HINCKLEY NATIONAL RAIL FREIGHT INTERCHANGE

Appendix 14 - Gibbet Hill Mitigation Road Safety Audit Stage 1

Stage 1 Road Safety Audit
RESPONSE REPORT GIBBET HILL

Report Title:	Hinckley National Rail Freight Interchange – Stage 1 RSA Gibbet Hill
Document Number:	HRF-BWB-HGN-RSA-RP-CH-0007
Prepared By:	BWB Consulting Ltd
Overseeing Organisation:	National Highways
BWB Reference:	NTT2814

Drawing Title  
**GIBBET HILL PROPOSED MITIGATION (SWEPT PATHS)**

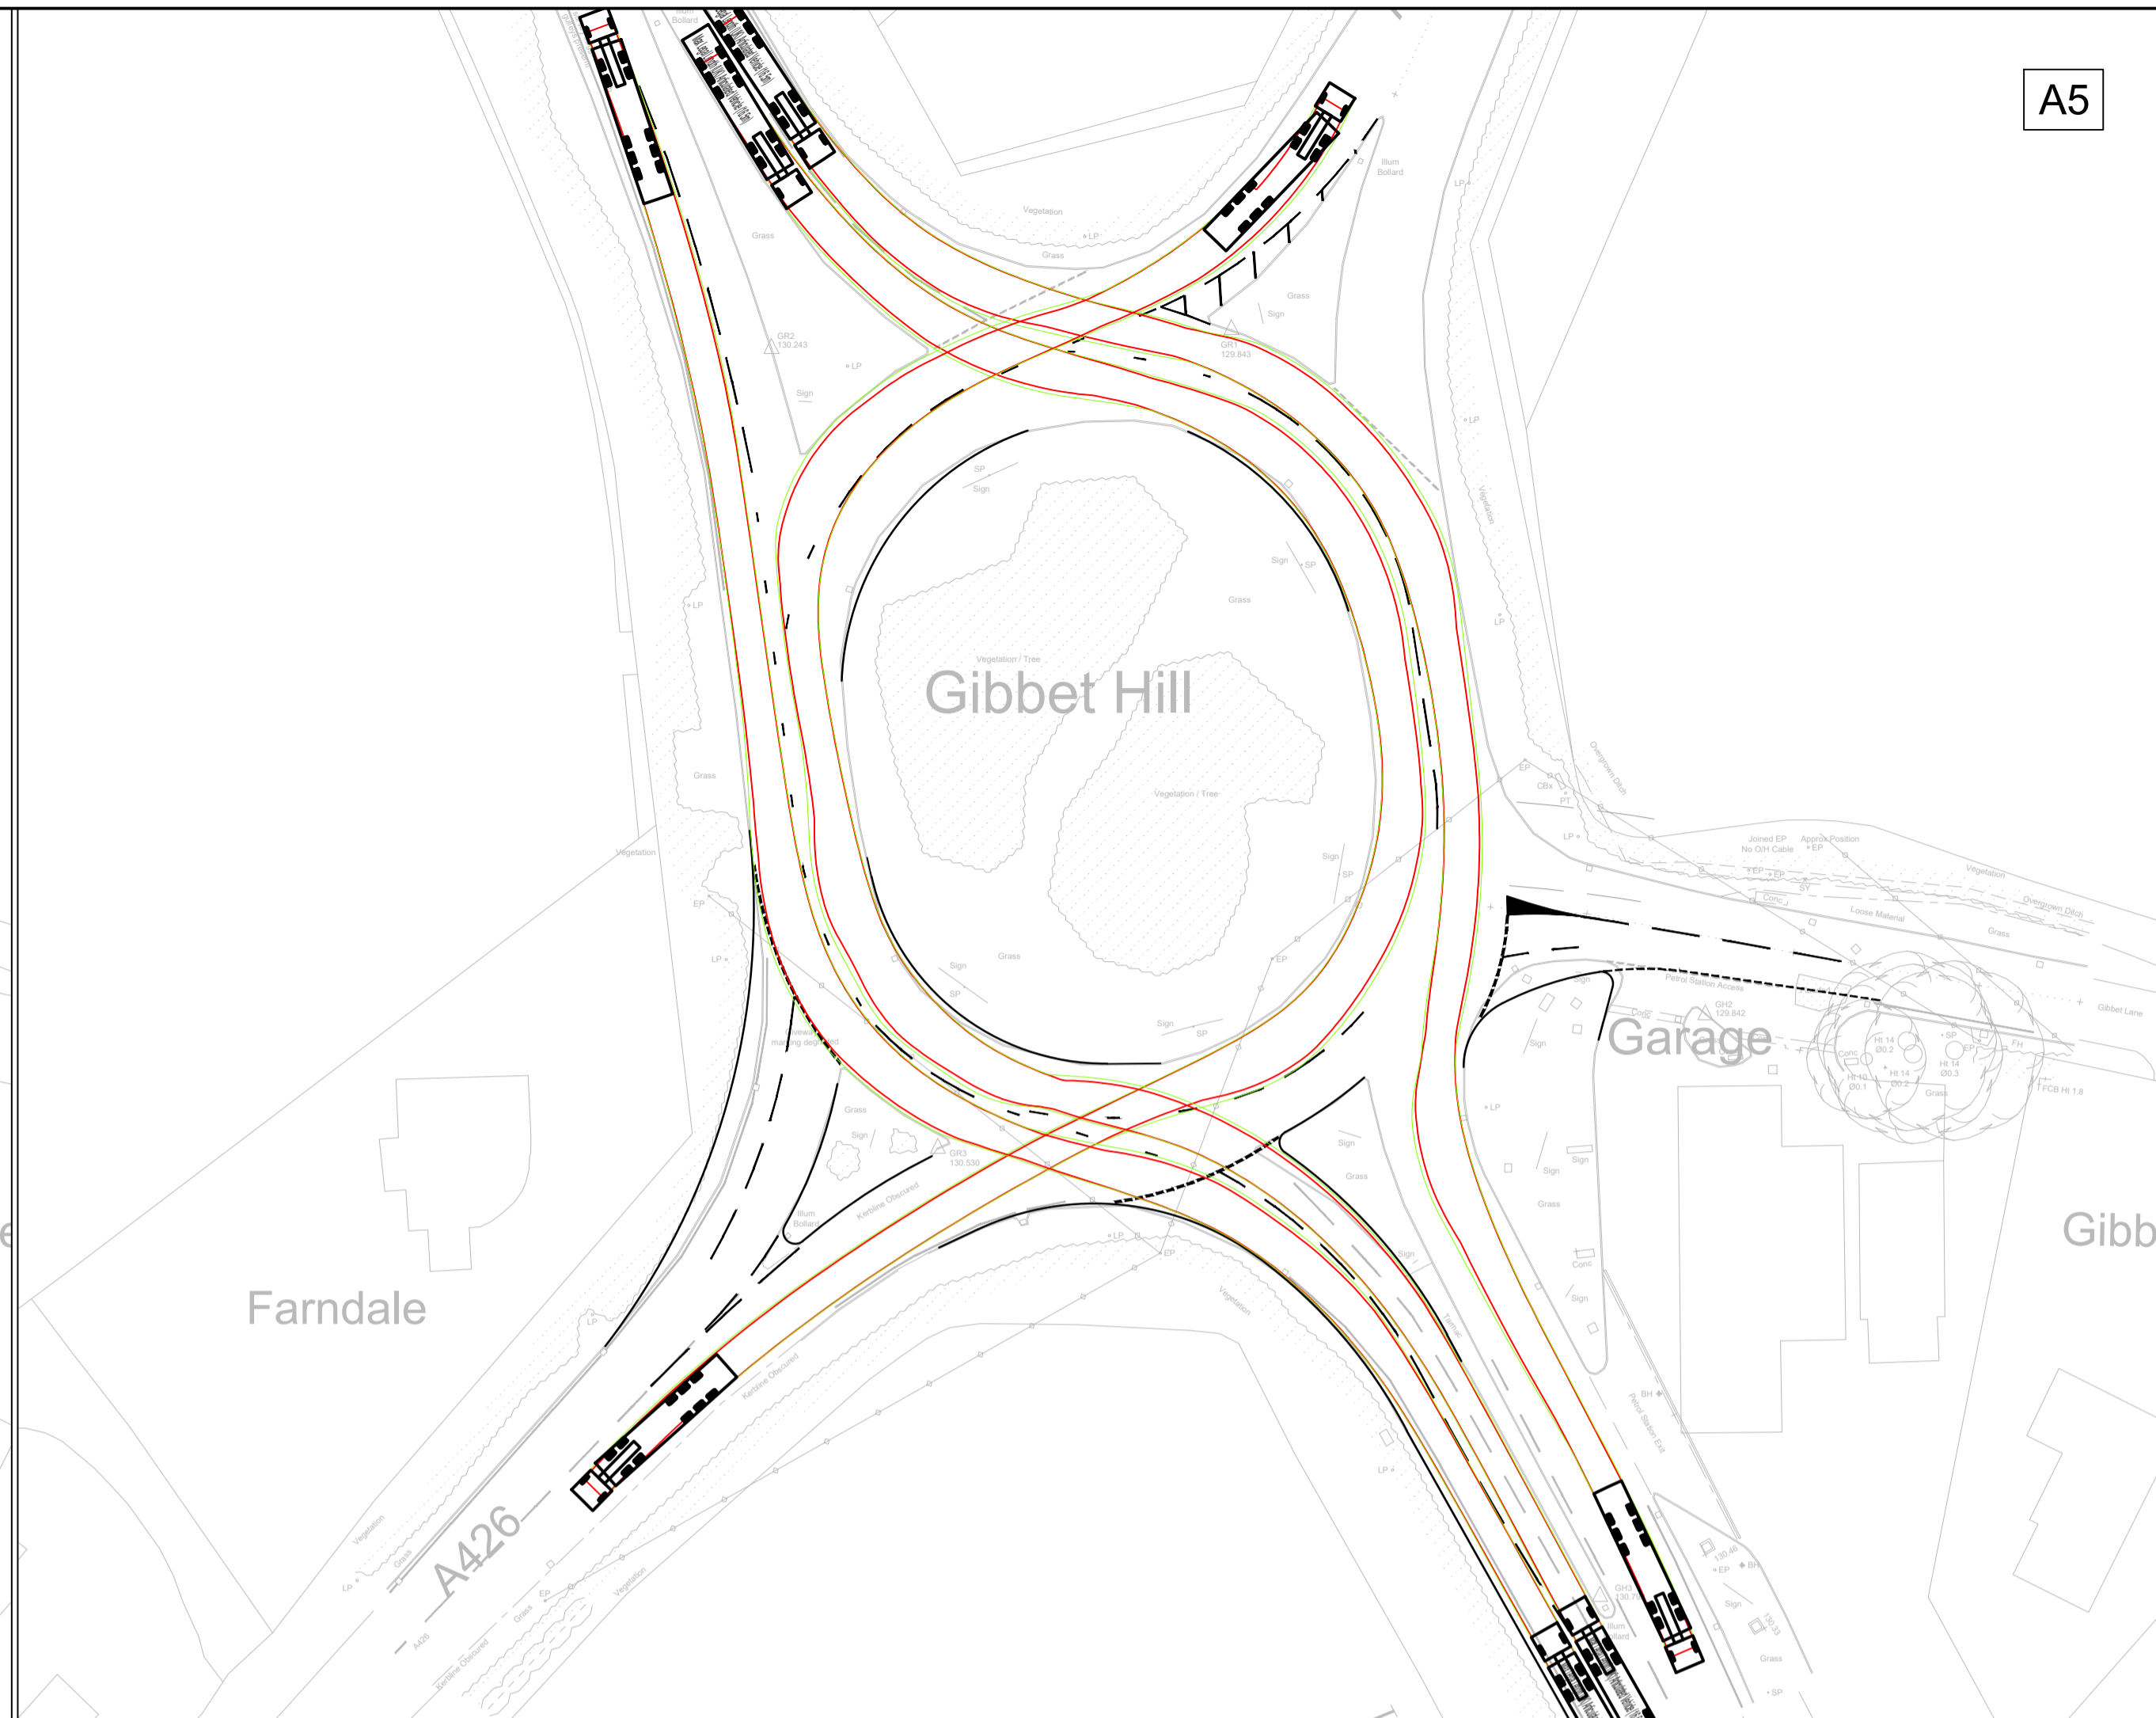
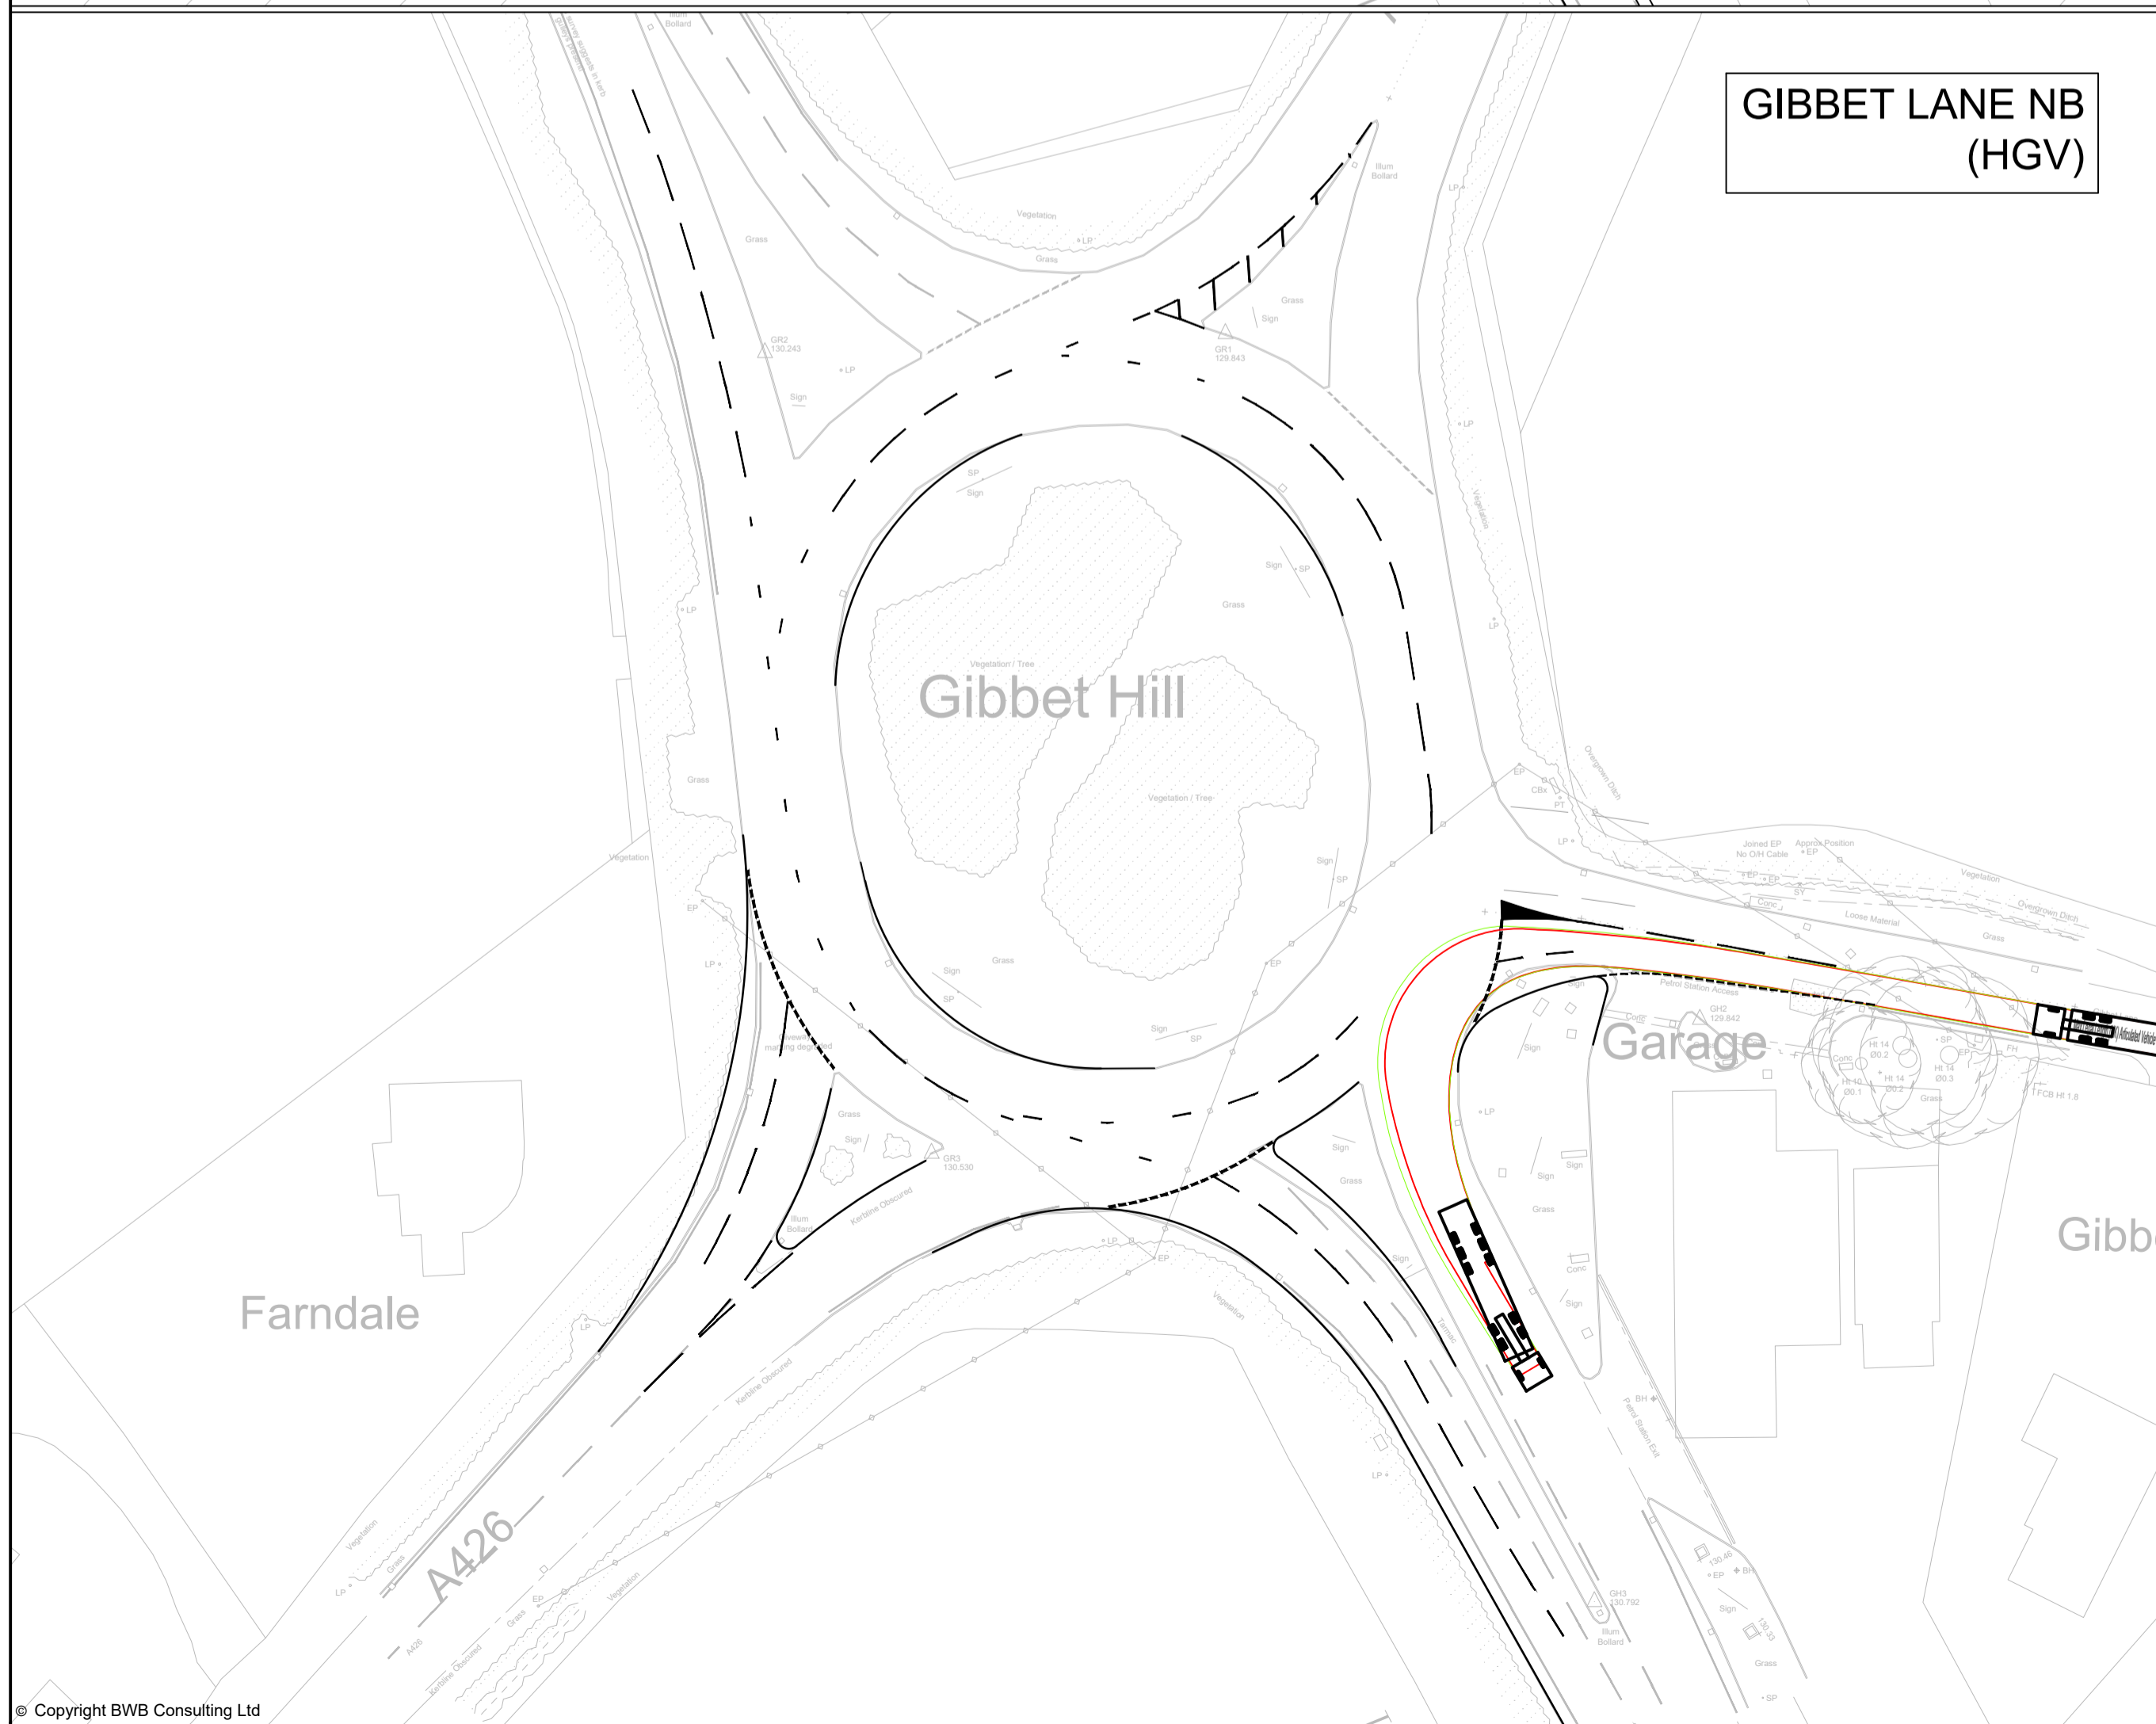
RSA Ref.	RSA Problem and Recommendation	Design organisation response	Auditor Response	Agreed RSA action
2.3	<p>Location: General to the scheme</p> <p>Summary: Potential collisions associated with insufficient circulatory width</p> <p>The formalisation of the two lane entries from A5 northbound, A426 eastbound and Gibbet Lane is likely to increase the occurrence of vehicles, particularly HGVs, using the circulatory carriageway two abreast. While the swept path drawings supplied to the RSA team suggest that this is achievable, site observations showed that there is evidence of significant overrun of the central island kerb line (on both the west and east sides) suggesting that there is insufficient width on the circulatory to safely accommodate two HGVs. This is compounded by the lack of road markings on the roundabout circulatory and all exits from the roundabout are single lane. Collectively this could lead to an increase in collisions on the circulatory, and side swipe collisions at the exits as two vehicles attempt to leave the roundabout at the same time.</p> <p>There is also a risk of an increase in HGVs overrunning the verge and central island bringing mud onto the carriageway which is particularly hazardous for powered two wheelers.</p> <p>Recommendation</p> <p>Review the swept path at the junction taking into consideration what could be happening in reality at present at the roundabout and if necessary, revise the kerb lines around the circulatory to ensure sufficient width is provided as part of the scheme.</p>	<p>Agree with RSA Recommendation: Yes</p> <p>Swept paths have been rerun and the roundabout circulatory carriageway has been widened in a number of places where vehicle overrunning is a risk in order to provide sufficient space between swept paths. New road markings on the circulatory carriageway are proposed to guide vehicles to the correct destination and mitigate the risk of vehicle overrunning or conflict.</p>

RSA Ref.	RSA Problem and Recommendation	Design organisation response	Auditor Response	Agreed RSA action
2.4	<p>Location: General to the scheme Summary: Potential collisions resulting from a lack of road markings</p> <p>There is a general lack of road markings on the approaches to and exits from the roundabout. Increasing the number of entry lanes in turn increases the number of vehicles on the negotiating the roundabout at any one time. Many of the users will be unfamiliar with the area and the lack of road markings could lead to incorrect positioning resulting in late lane changes or hesitation which in turn could result in collisions.</p> <p>Recommendation Provide sufficient road markings on approach to, exits from and on the circulatory of the roundabout.</p>	<p>Agree with RSA Recommendation: Yes</p> <p>New road markings have been proposed throughout the junction to ensure that vehicles are in the correct lane and to mitigate the risk of conflict.</p>
